25<sup>th</sup> April 2024

**Forestry Commission responses to Examination questions regarding Rampion 2 Offshore Wind Farm**

- **Graphic A-2:** Indicative illustration of vegetation notched to 6m and showing new planting;
- **Graphic A-3:** Indicative illustration of vegetation notched to 14m and showing new planting; and
- **Graphic A-4:** Indicative illustration of vegetation cleared to 20m and showing new planting.

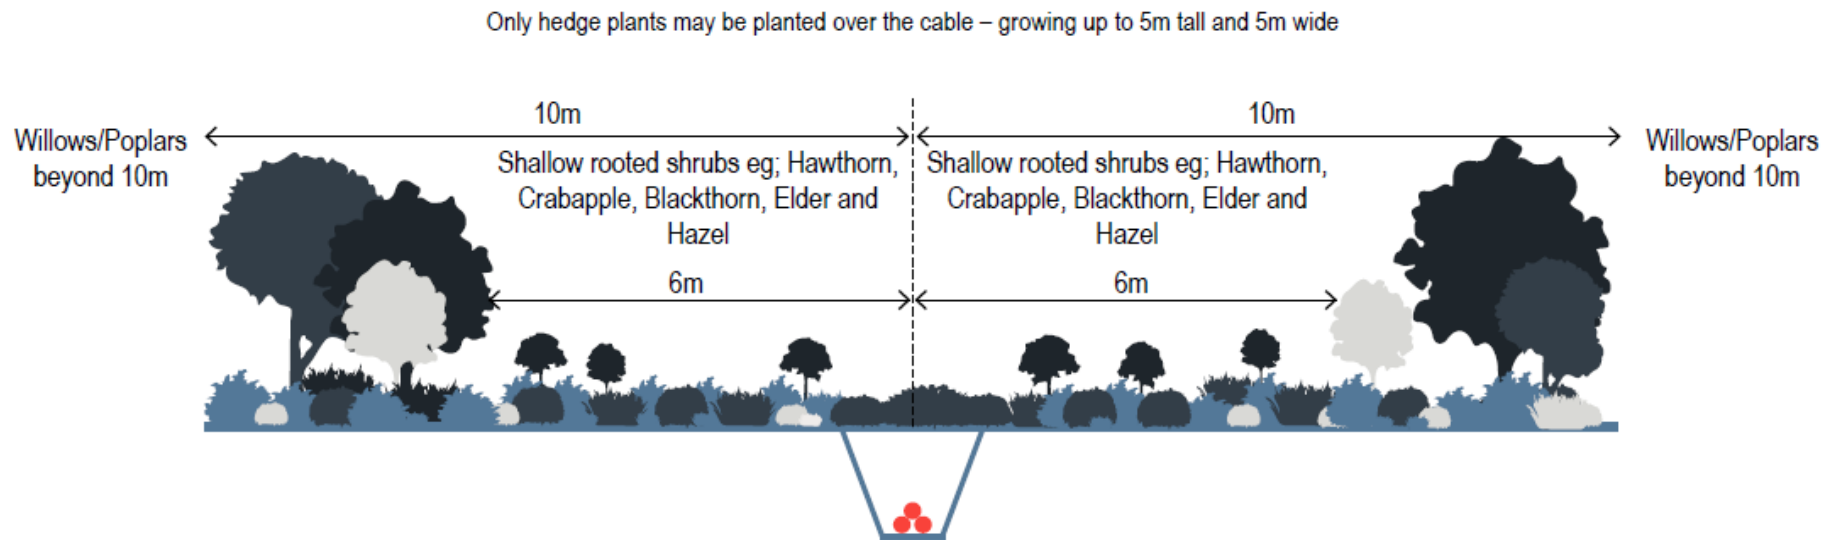
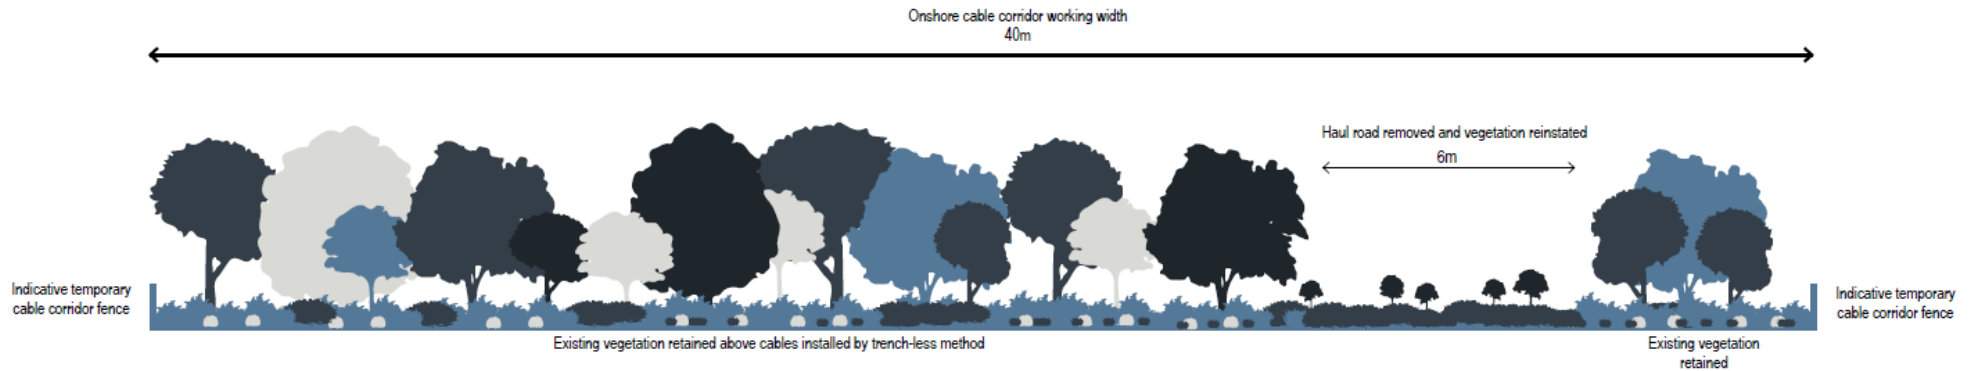
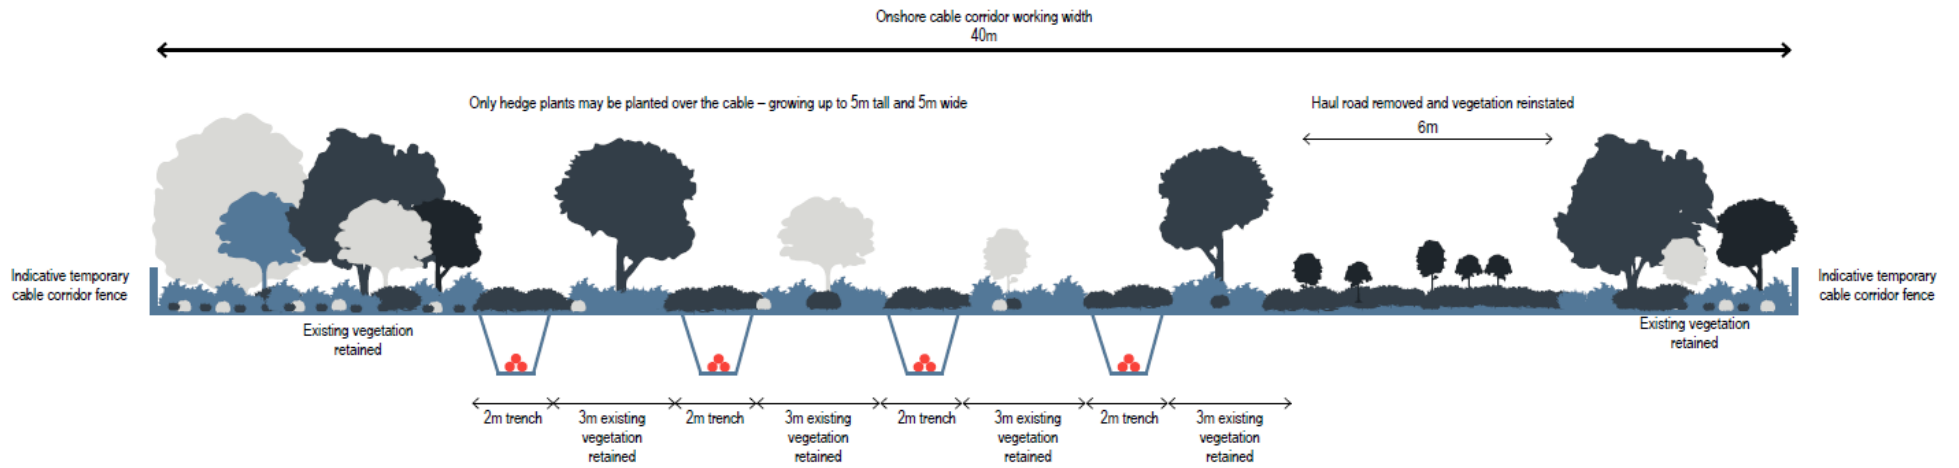
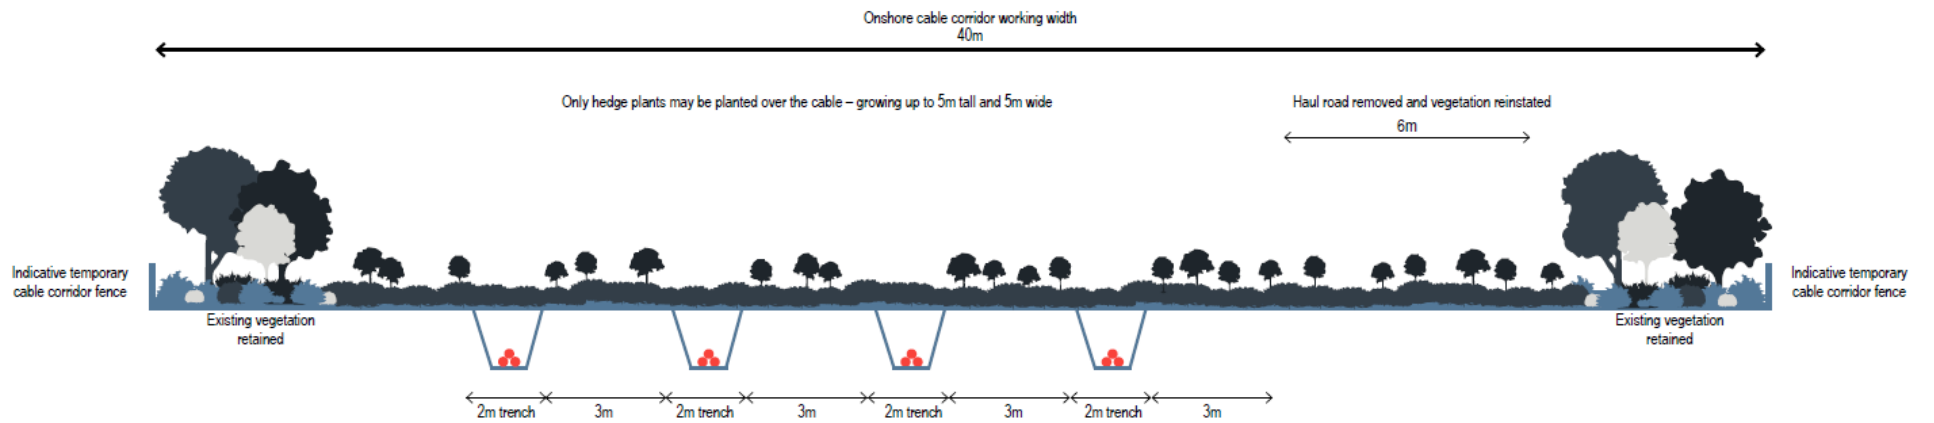
### **3. TE 1.31 Approach to hedge notching**

We have no further comments regarding hedge notching at this time except that we support in principle that this be accompanied by suitable monitoring and restocking to ensure measures are achieved in practice, in addition to the measures requested above to improve connectivity,
